From: [REDACTED]
To: [Norfolk Boreas](#)
Subject: Norfolk Boreas Project EN010087.
Date: 29 April 2020 21:51:08

The applicant refers to their Outline Landscape and Ecological Management Strategy 8.7 4. Embedded Mitigation.

Title:	Scenario 1 Viewpoint 4: A47 Necton Substation
--------	---

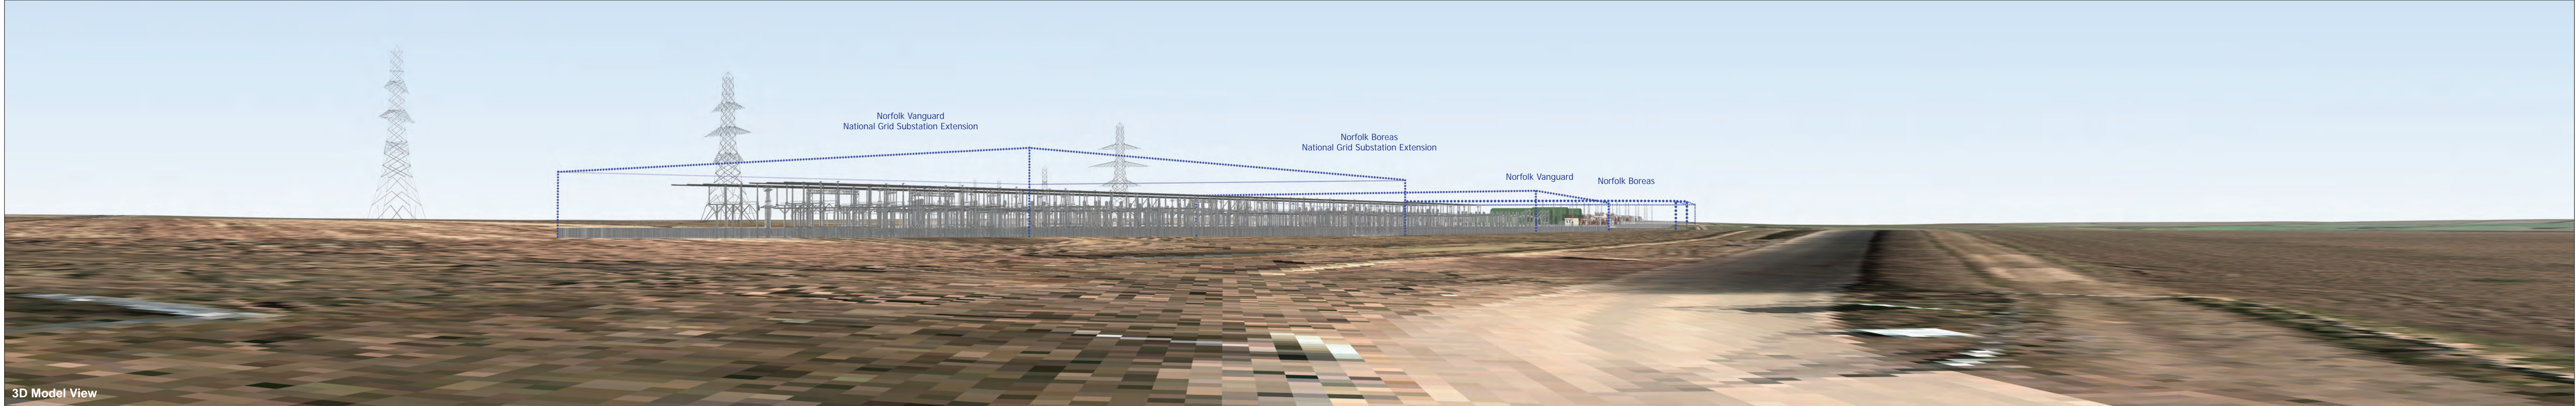
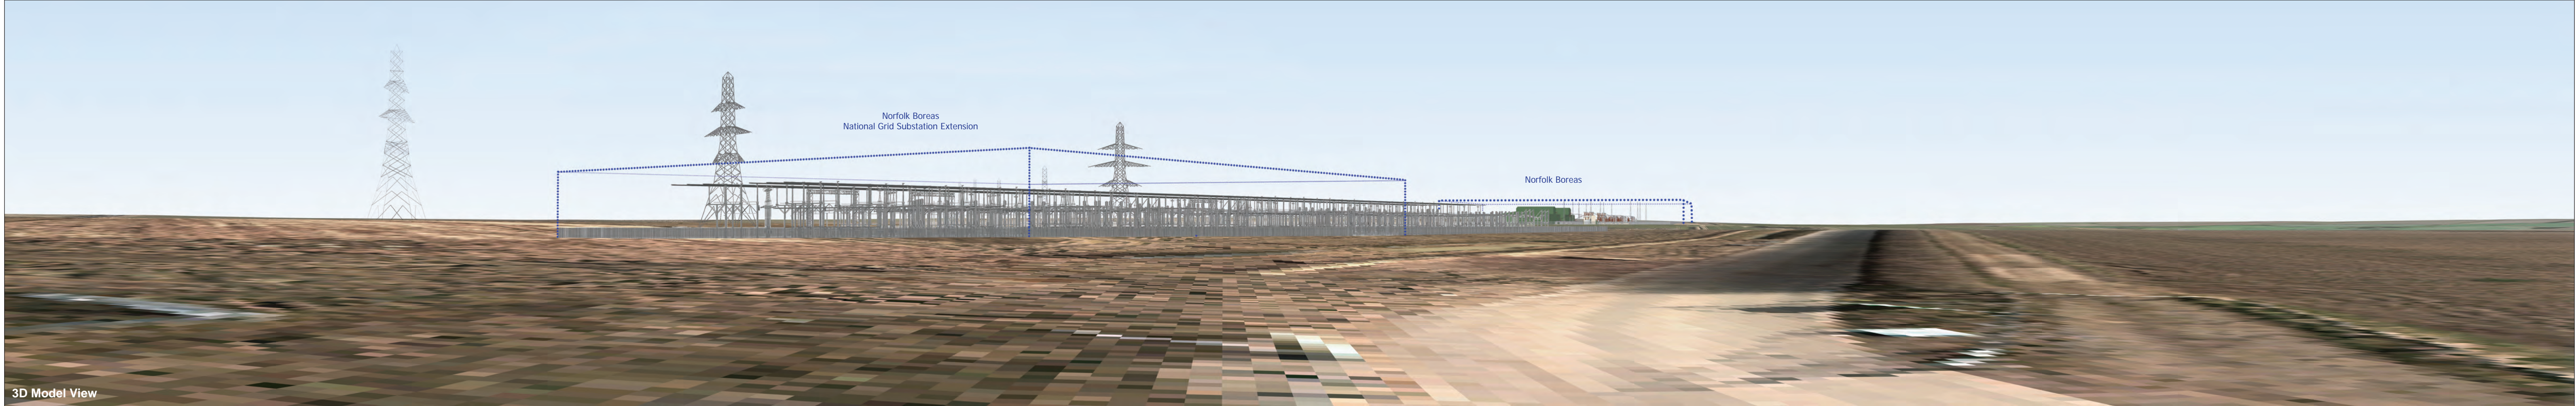
The 2 woods mentioned would only screen a limited number of viewpoints from Little Fransham and Bradenham Hall area of Bradenham. As the substation site is 70m above sea level, 19m tall buildings would be visible above the tree line. The opinion of the applicant that existing woods can successfully screen 19m high buildings, built on a 70m high Plato, and also showing the same effect with planted mitigation trees in photo montages, (view point 7) is a concern.

Plate 7 Refined Onshore Project Substation Zone

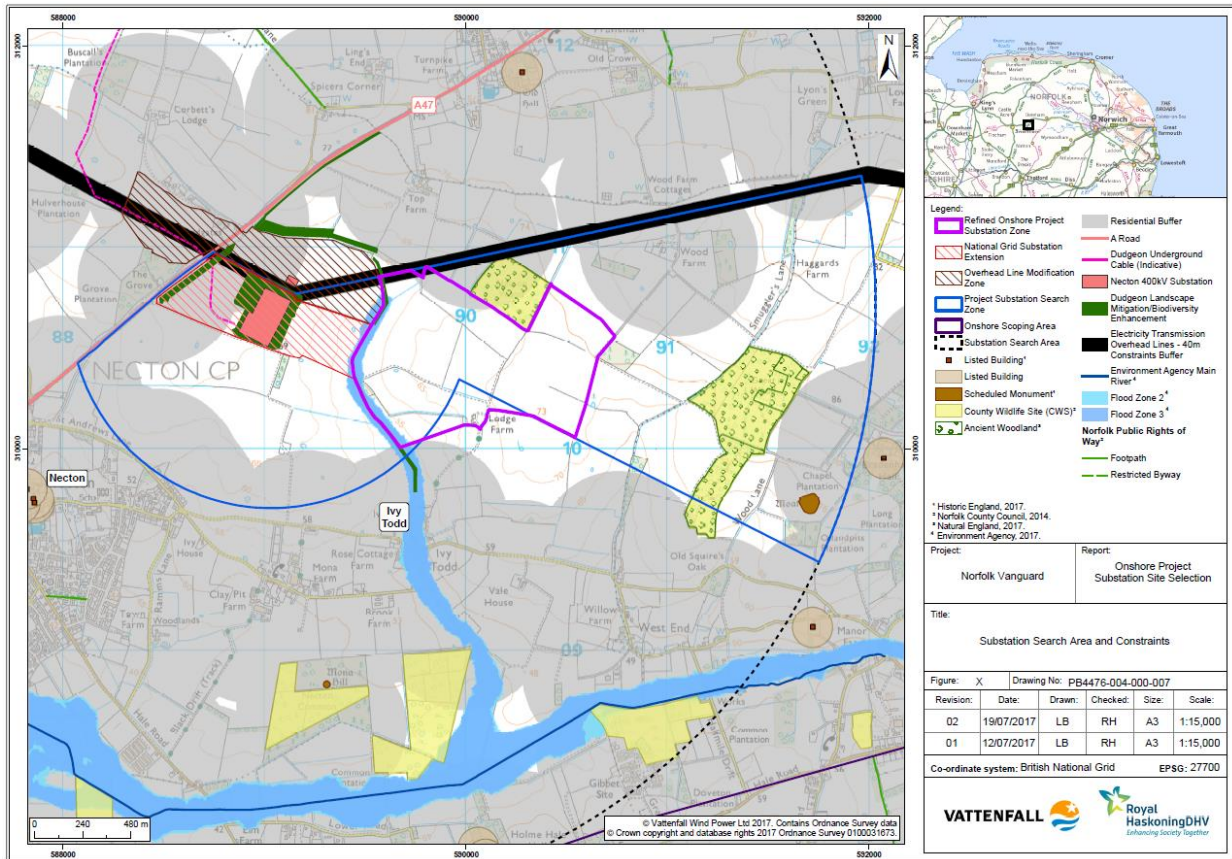
Regarding the National Grid Substation extension site selection, the applicant suggests in accordance with the Horlocks Rules, it is an advantage to develop adjacent to existing constructions, eg. building the National Grid connection point onto the existing substation and connection to contain these developments within a localised area, and in doing so would contain the extent of the landscape and visual effects. This has some merit, but as an infrastructure site grows with additional developments, a revaluation of the mitigation methods is needed. Initially a 20 acre substation may be adequately mitigated with hedges and young trees, but as it grows to 70 acres plus, with buildings 19m high, it cannot be considered adequate to simply extend the same hedges and young trees to mitigate the new infrastructure of totally different scale and character. As the development grows in scale its visual impact multiplies, and new techniques of mitigation are needed.
